From: Contact Centre (CRM) <contact@ribblevalley.gov.uk>
Sent: 17 May 2022 16:57
To: Planning
Subject: Planning Application Comments - 3/2022/0421

Planning Application Reference No.: 3/2022/0421

Address of Development: 21 Paris, Ramsgreave.

PROPOSED NORTH EAST ELEVATION (FRONT). SCALE 1:100

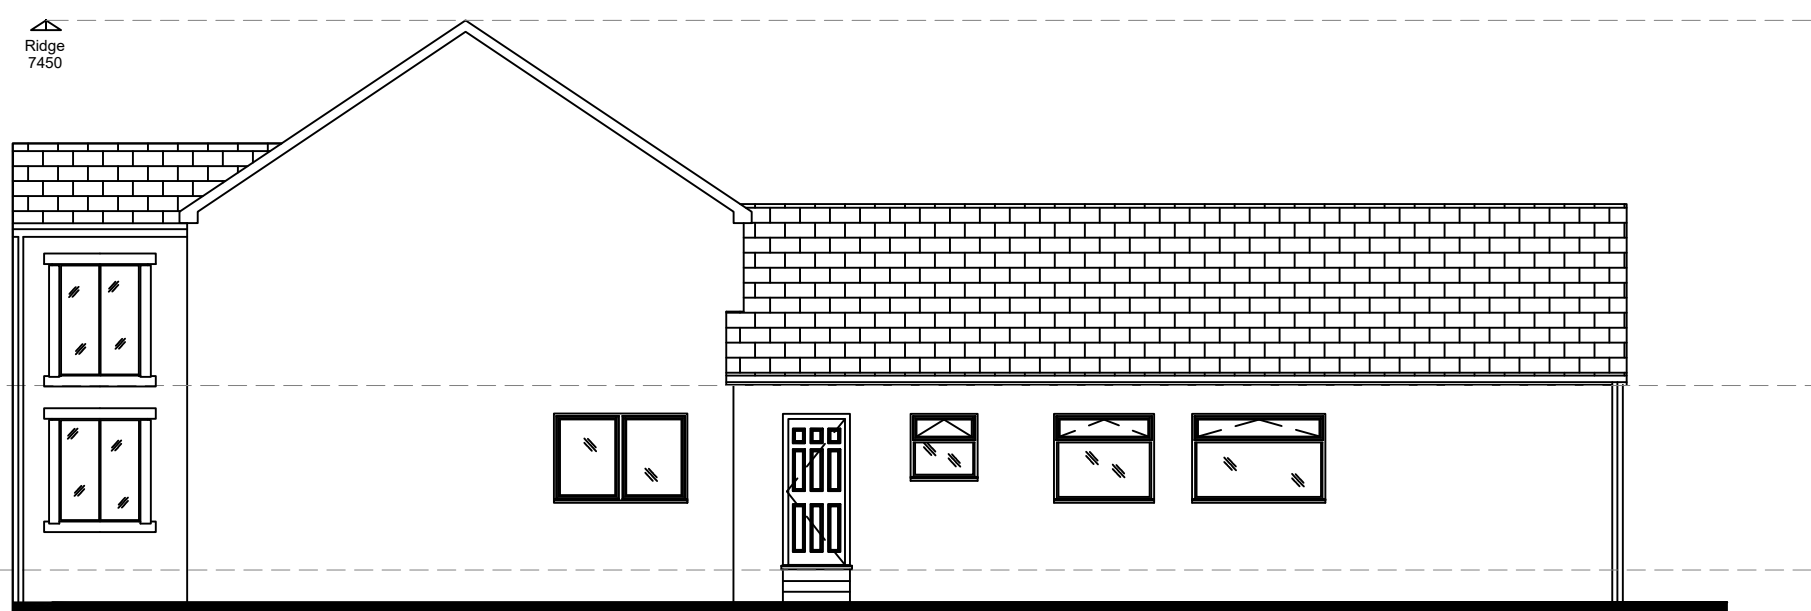
Comments: I do not object to the change to the porch structure at the front of the development. I do object to the insertion of the roof lights to the front of the dwelling and at the rear. They will have a significant impact on the

PROPOSED BLOCK PLAN (MINOR MODIFICATION TO CURRENT)

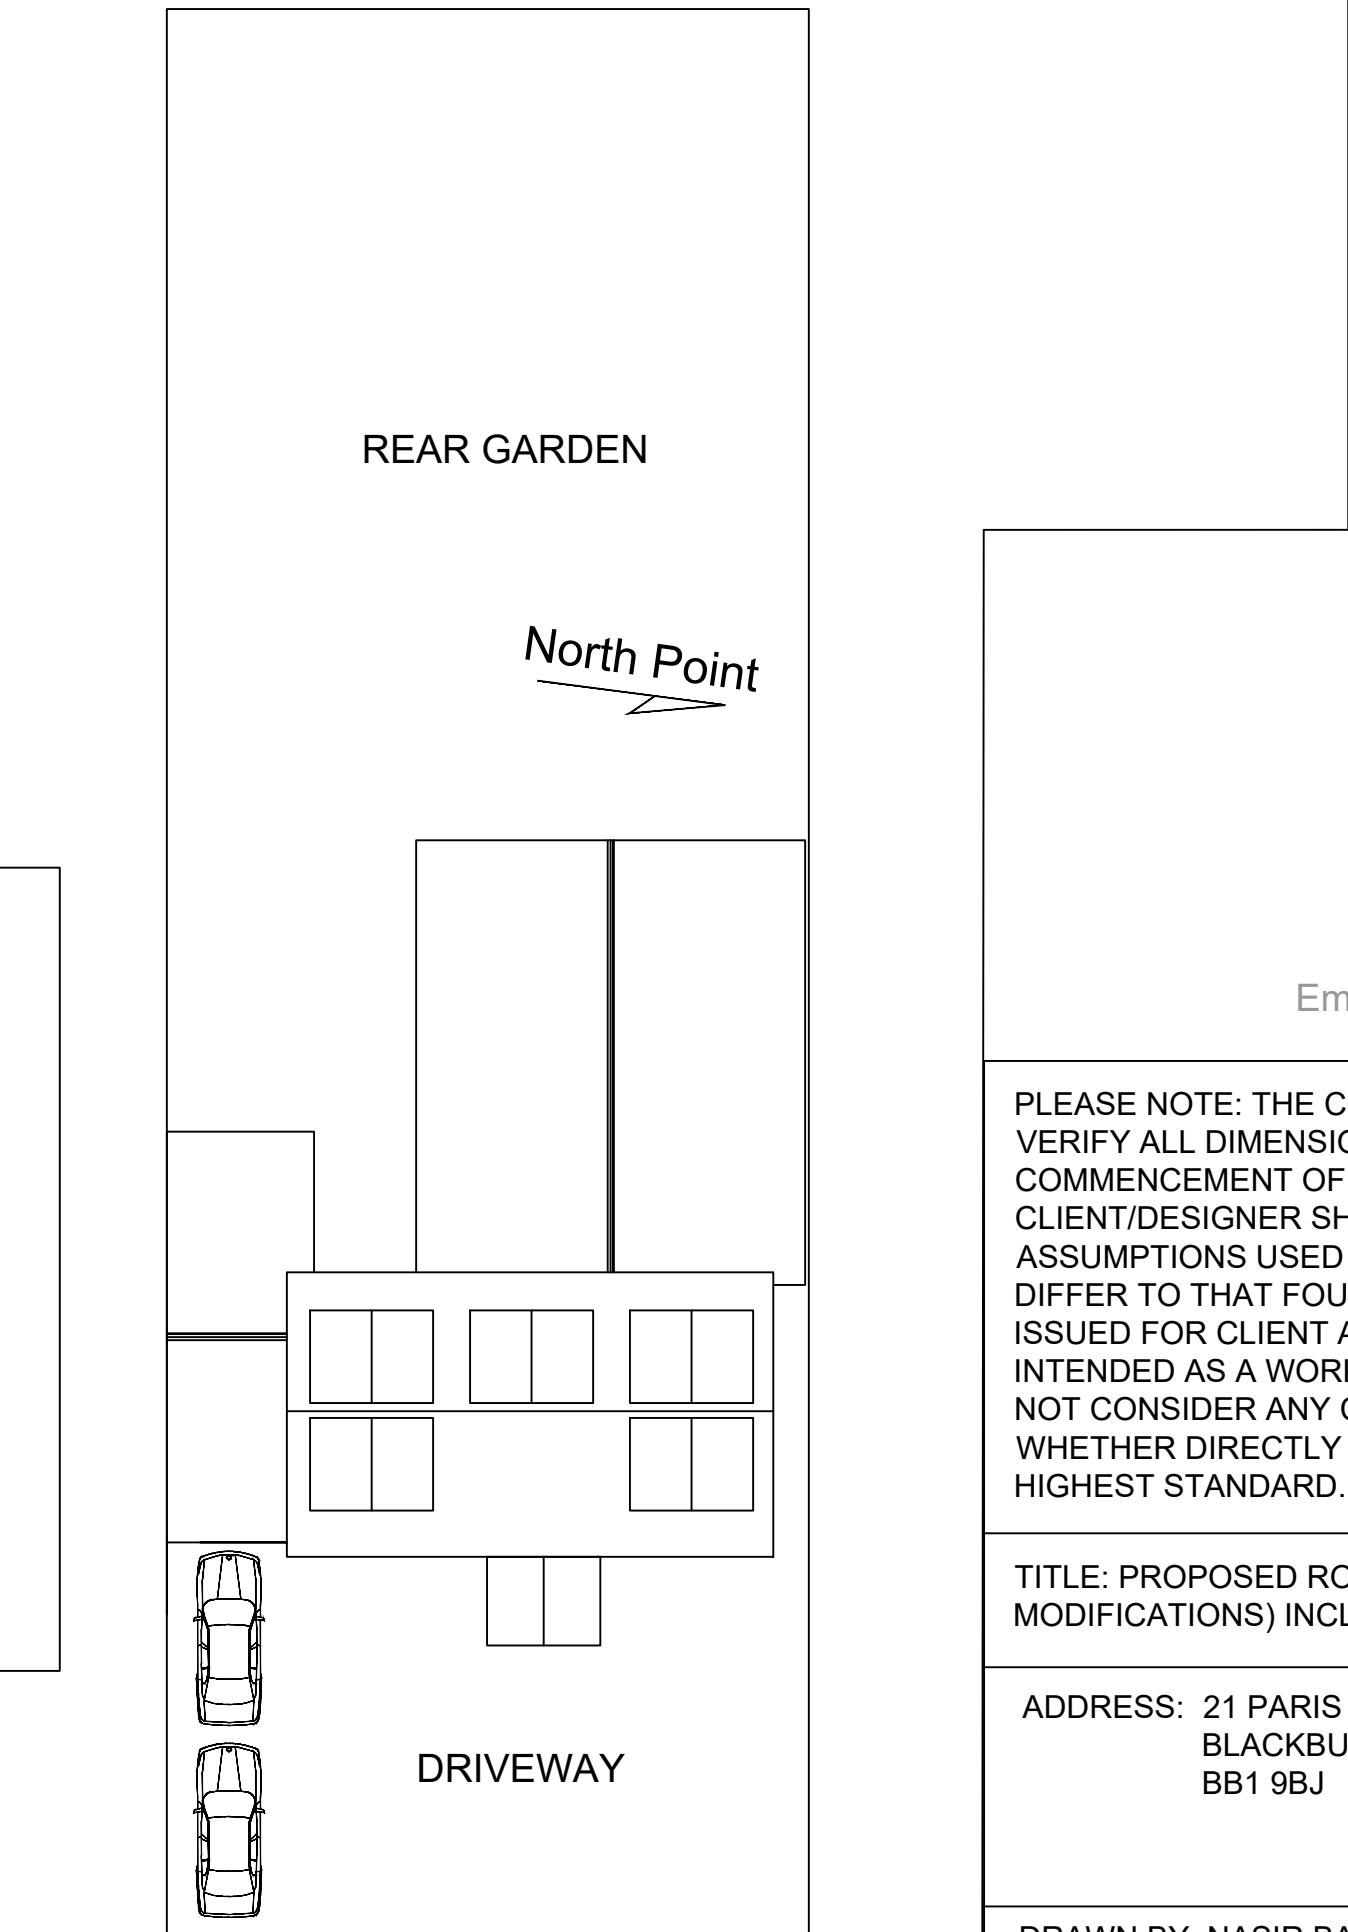
[REDACTED] I would also query why the roof lights are required in storage areas of the new development and again I suspect the applicant is again misleading the authority and that these will areas will obviously be additional bedrooms. The plans are again inaccurate and once again show the garage of the new build being built directly at the boundary wall when it should be 90 cm away to ensure they do not cause further damage.
